**Planning Department
Transportation Development Services**

November 7, 2014

Re: Chili's, 1700 Miles Road SE
Traffic Circulation Layout
Engineer's Stamp dated 11-06-14 (M15-D012B)

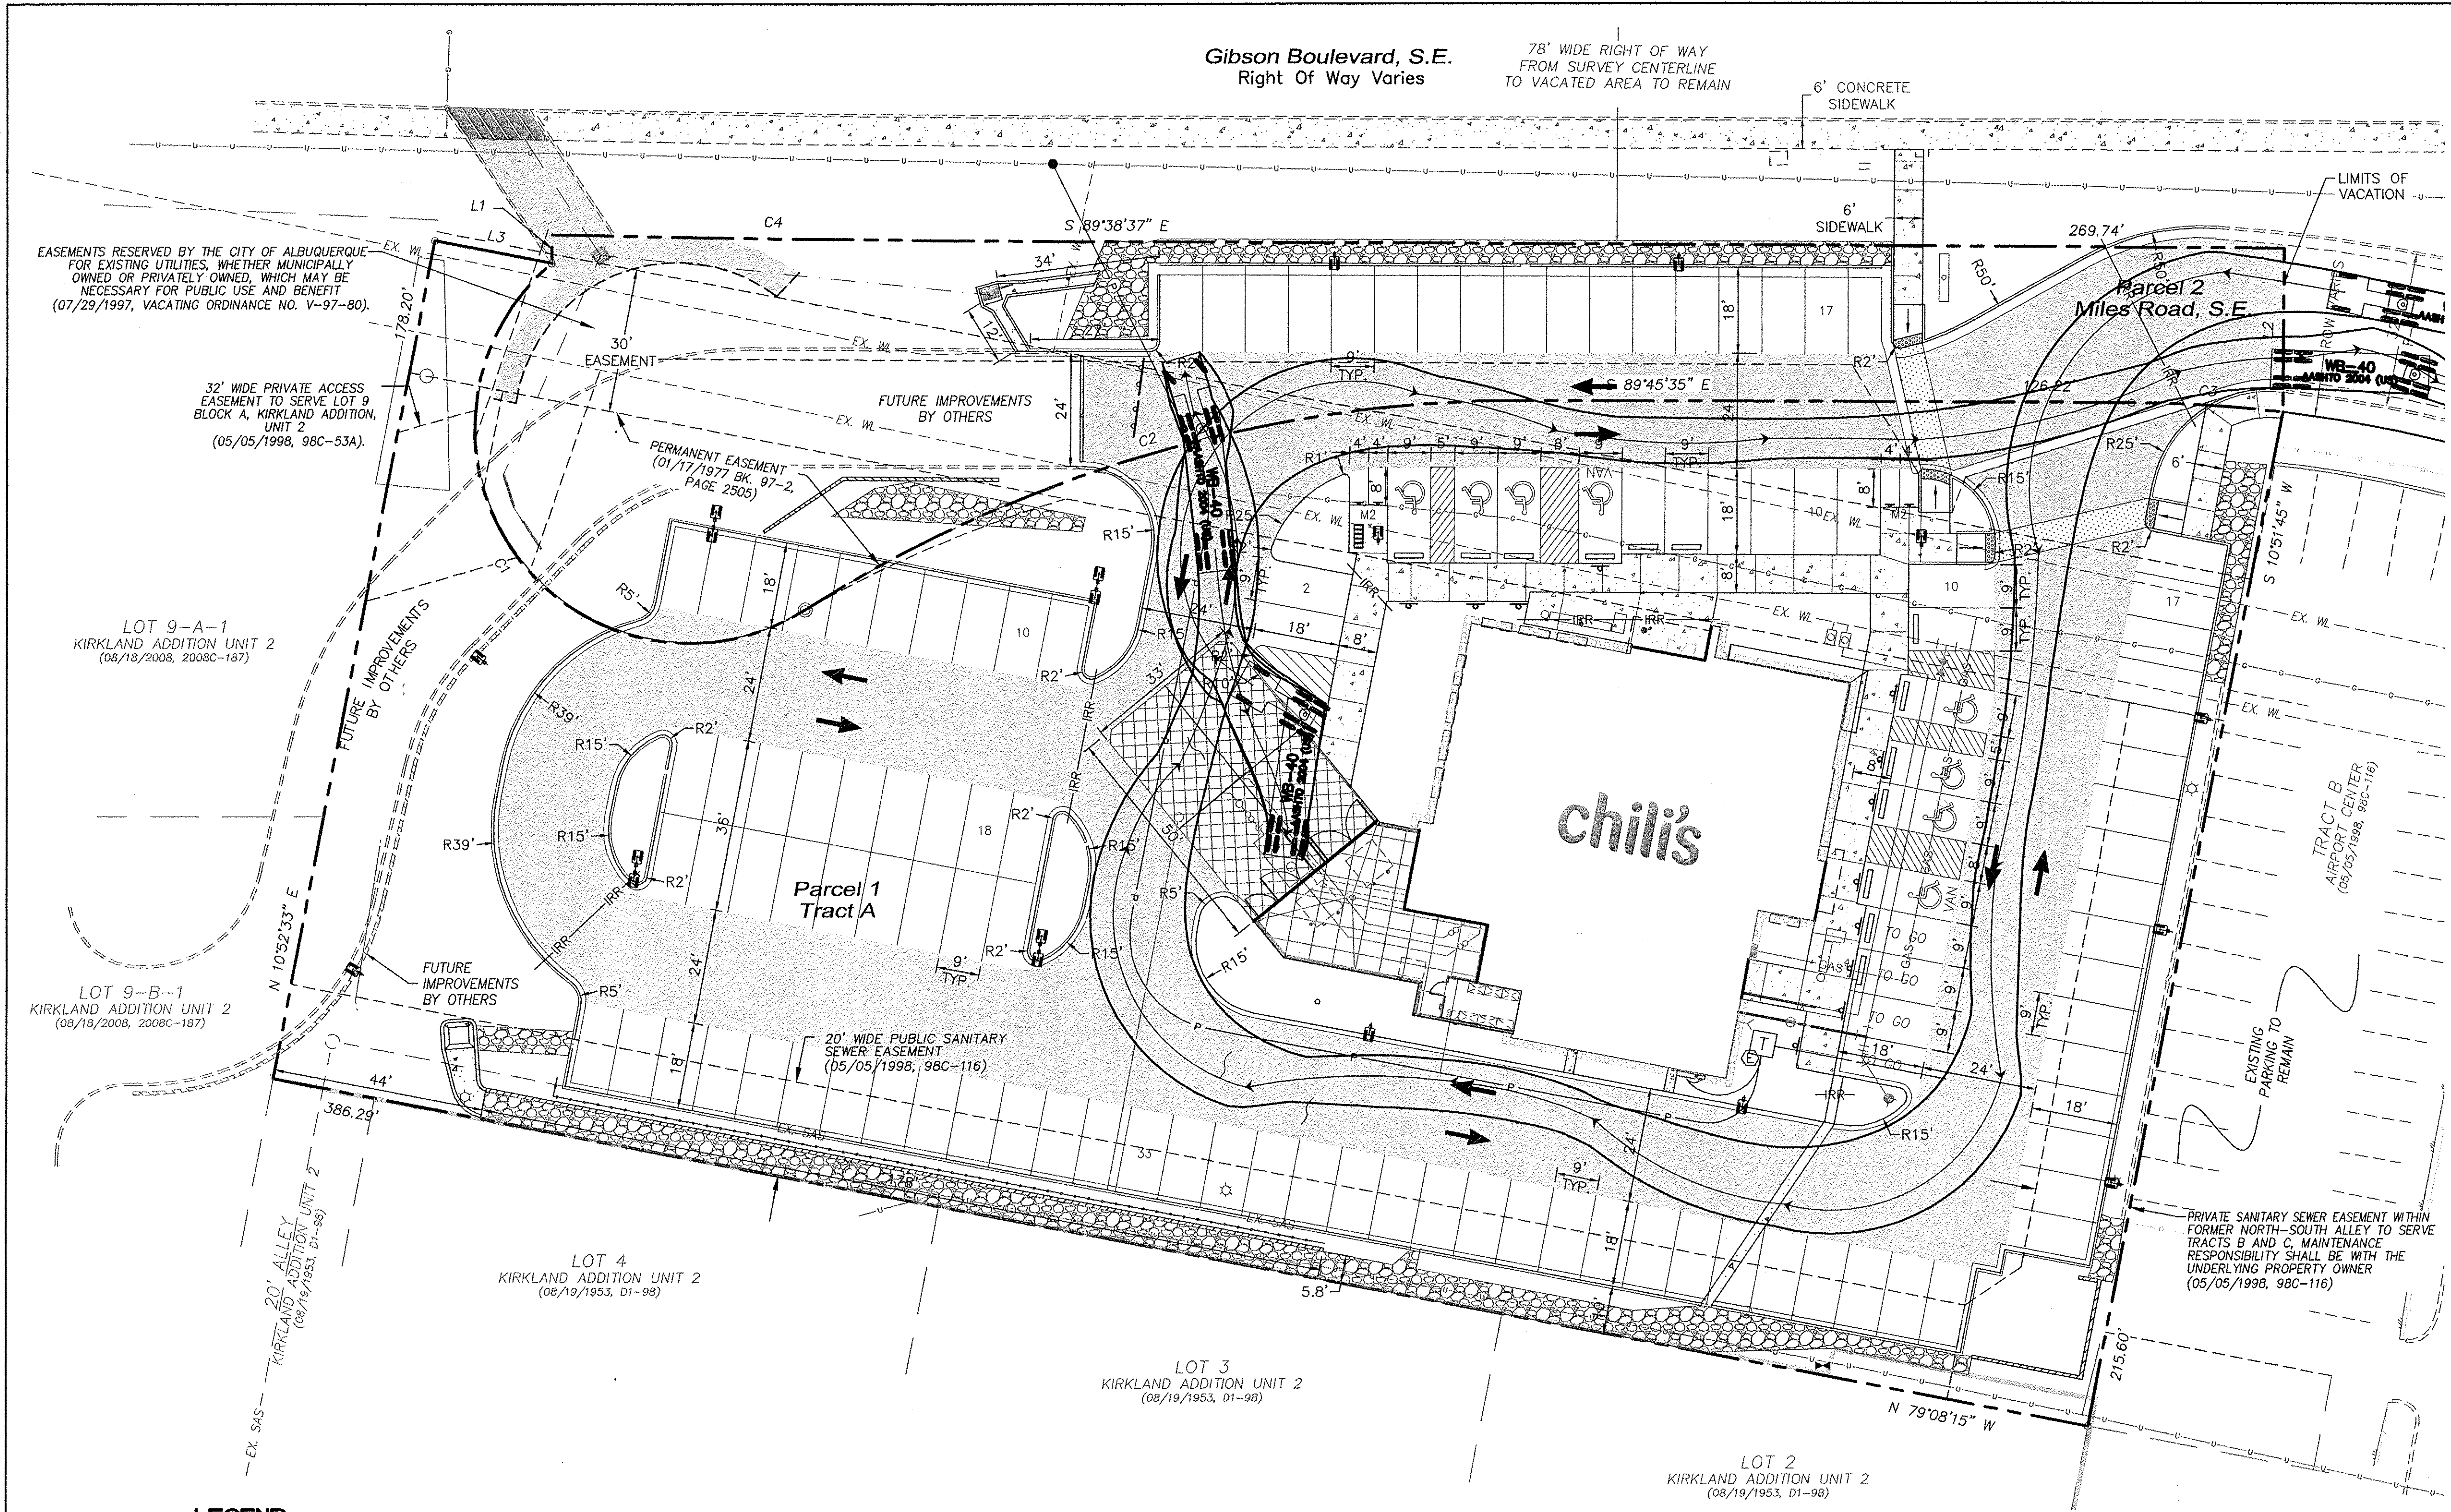
1. Please identify all door entrances to the new building, and list the square footage for the new building.
2. Identify existing pavement, sidewalk, and right-of-way dimensions for Gibson Boulevard. Label and list the dimension for the easement across the site to the north of the new building.

4. The two 8-foot wide ADA access aisles shall have the words **"NO PARKING"** in capital letters, each of which shall be at least one foot high and at least two inches wide, placed at the rear of the parking space so as to be close to where an adjacent vehicle's rear tire would be placed. (66-1-4.1.B NMSA 1978)

5. Per the DPM, a 6-foot wide ADA accessible pedestrian pathway is required from the public sidewalk to the building entrances. Please extend the 6-foot pathway that you have shown on the plan all of the way to the existing sidewalk on Gibson Boulevard.

6. The design delivery vehicle route needs to be shown. Also, provide a separate sheet showing delivery truck turning movements.

7. Reference the DRB Case Number for the Miles Road vacation, and define limit of the vacation for Miles Road toward the east side of the site. Label the existing Miles Road public road right-of-way and pavement dimensions to the east of the site.
8. Please include two copies of the traffic circulation layout at the next submittal.

7 ACCESSIBLE PARKING LOT SIGN
 NTS

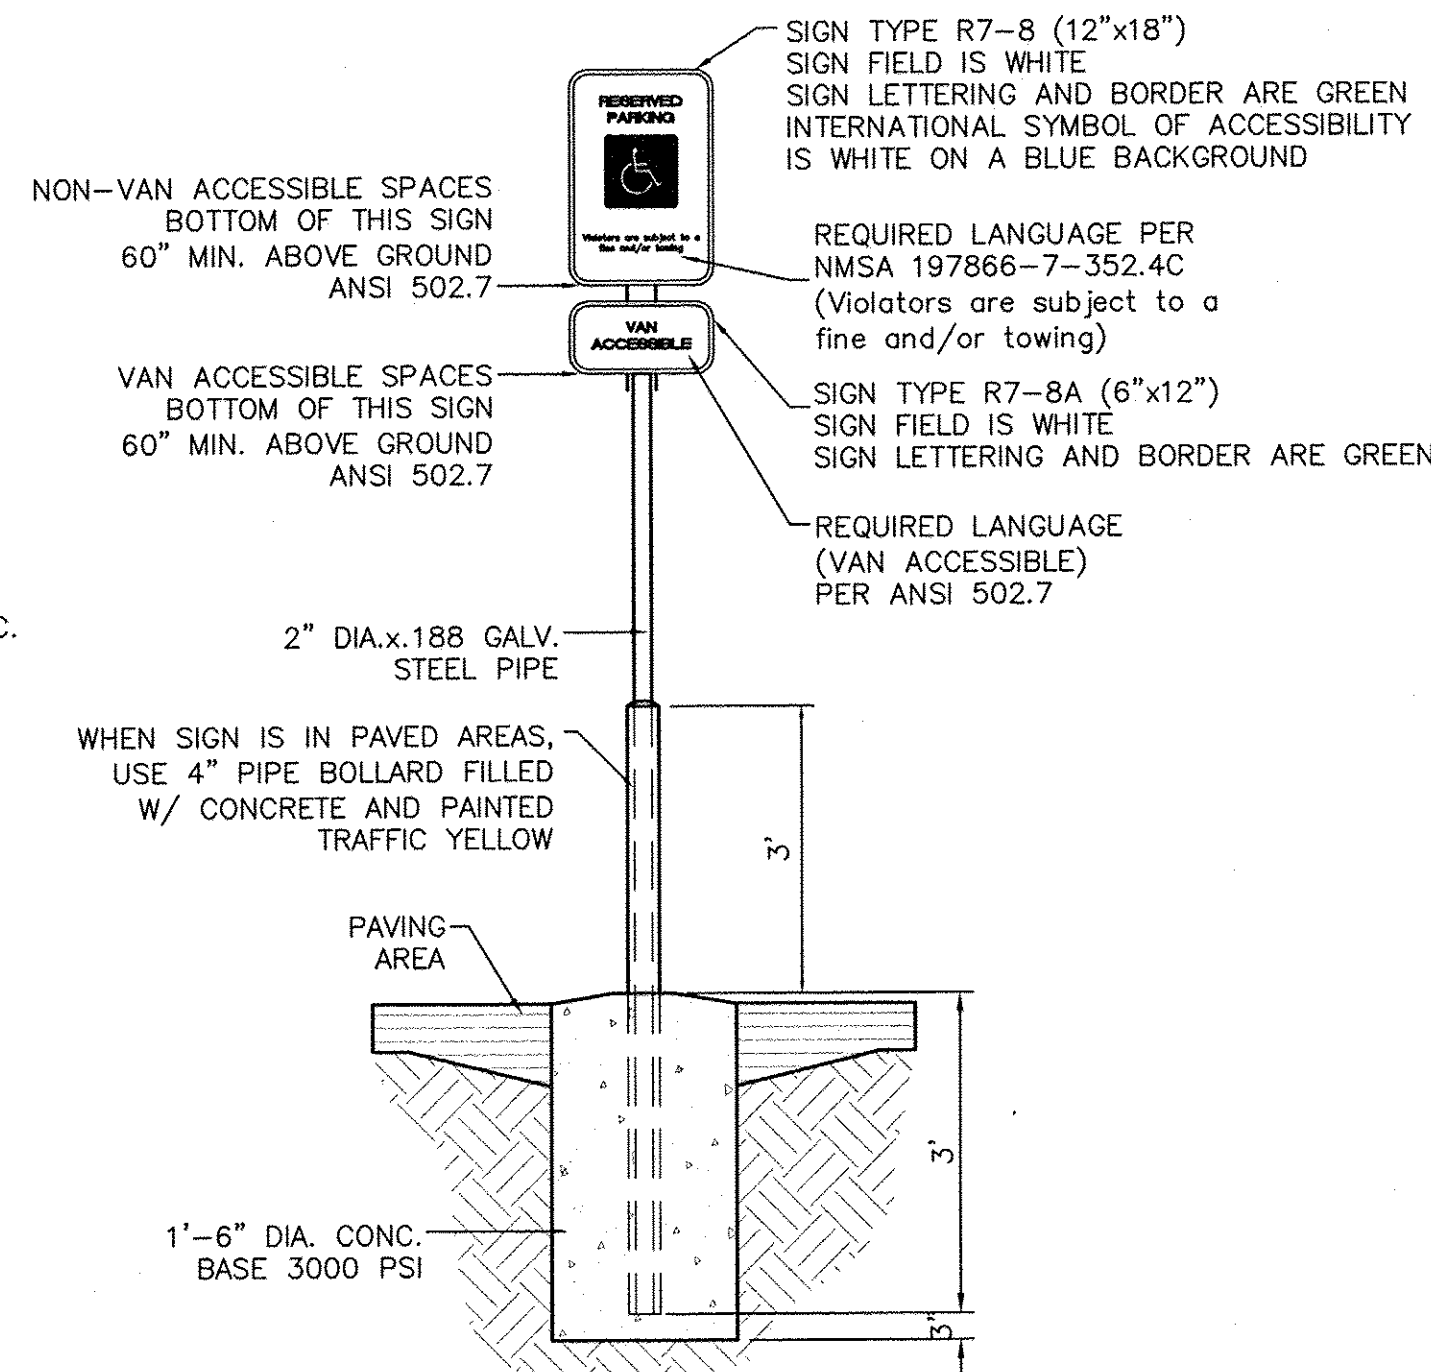
3. Provide Plan Sheets C6 through C8 which show remaining details for signage, curb, and pedestrian ways. The ADA van accessible sign must have the required language per 66-7-352.4C NMSA 1978 "Violators Are Subject to a Fine and/or Towing." There must also be the required language indicating "Van Accessible" per ANSI 502.7.
